WEST SUSSEX COUNTY COUNCIL CONSULTATION

TO:	Arun District Council FAO: Amber Williard
FROM:	WSCC - Highways Authority
DATE:	17 February 2021
LOCATION:	16 North End Road Arundel BN18 0DJ
SUBJECT:	Y/10/21/DOC Approval of details reserved by condition imposed under ref Y/129/20/HH relating to Condition No 3 - vehicular access.
DATE OF SITE VISIT:	n/a
RECOMMENDATION:	Advice
S106 CONTRIBUTION TOTAL:	n/a

DWG. NO. JHB/327/307/2

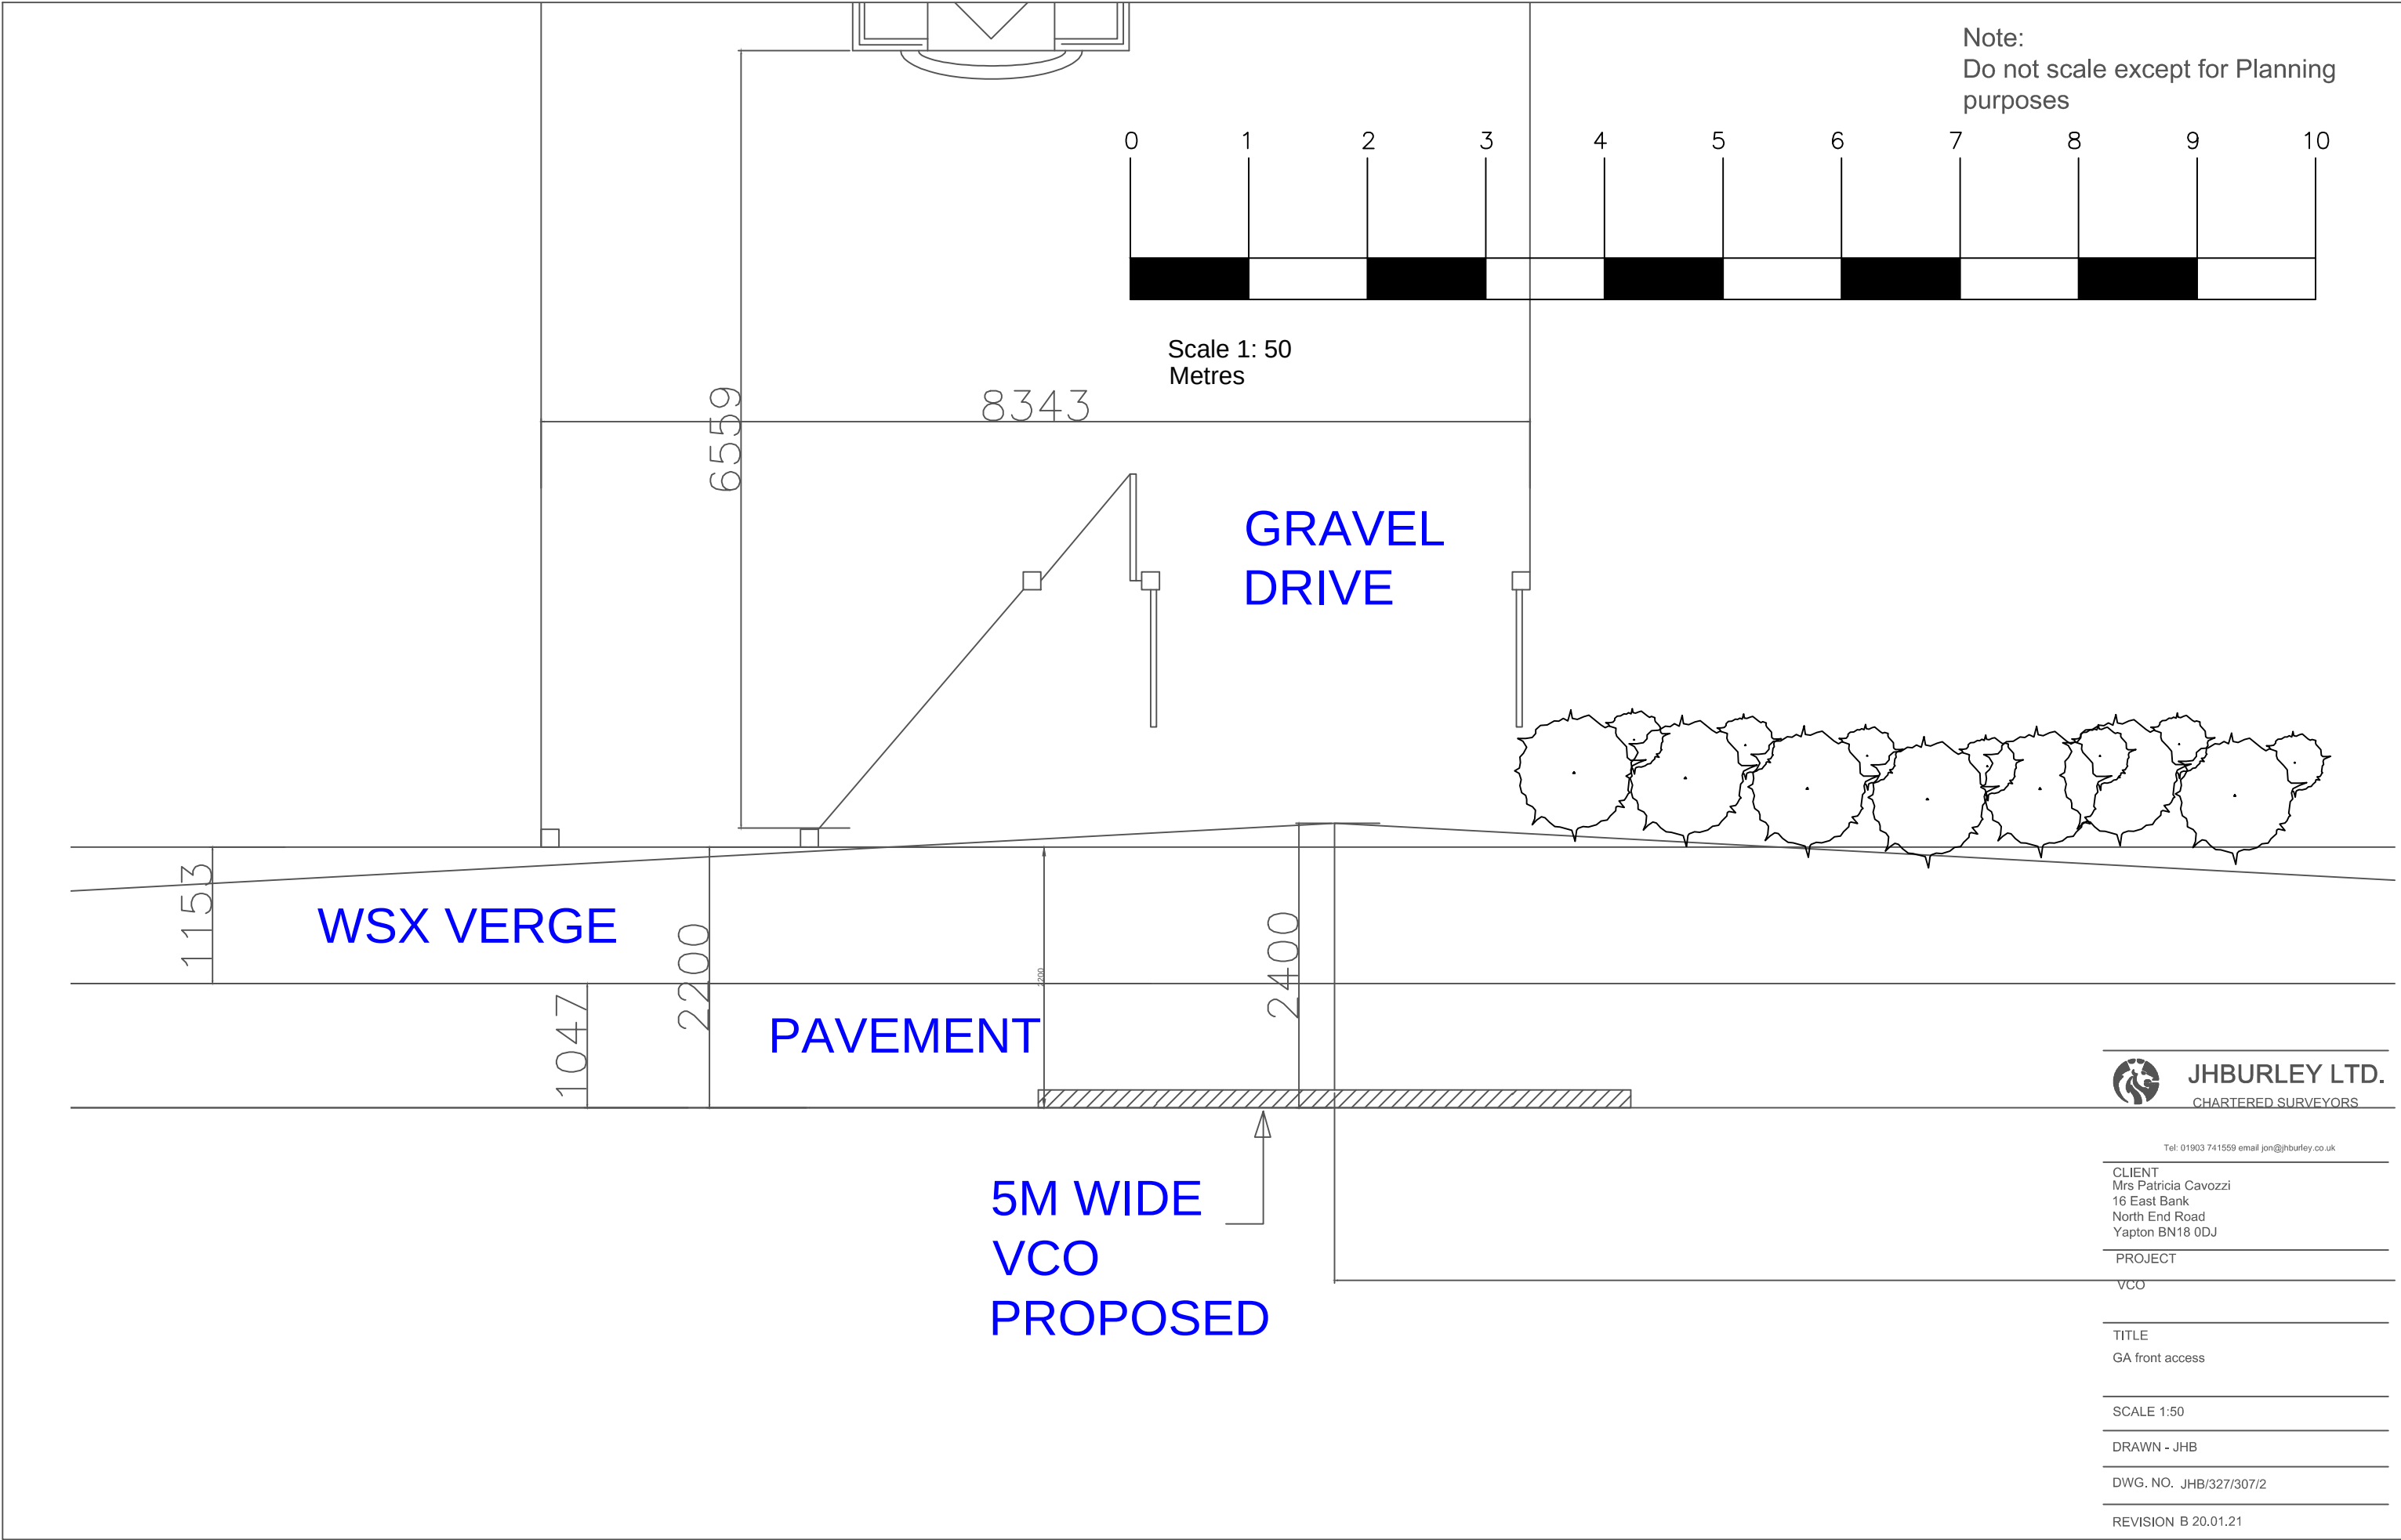
The applicant proposes a 5 metre Vehicle Crossover (VCO).

The LHA accepts these details.
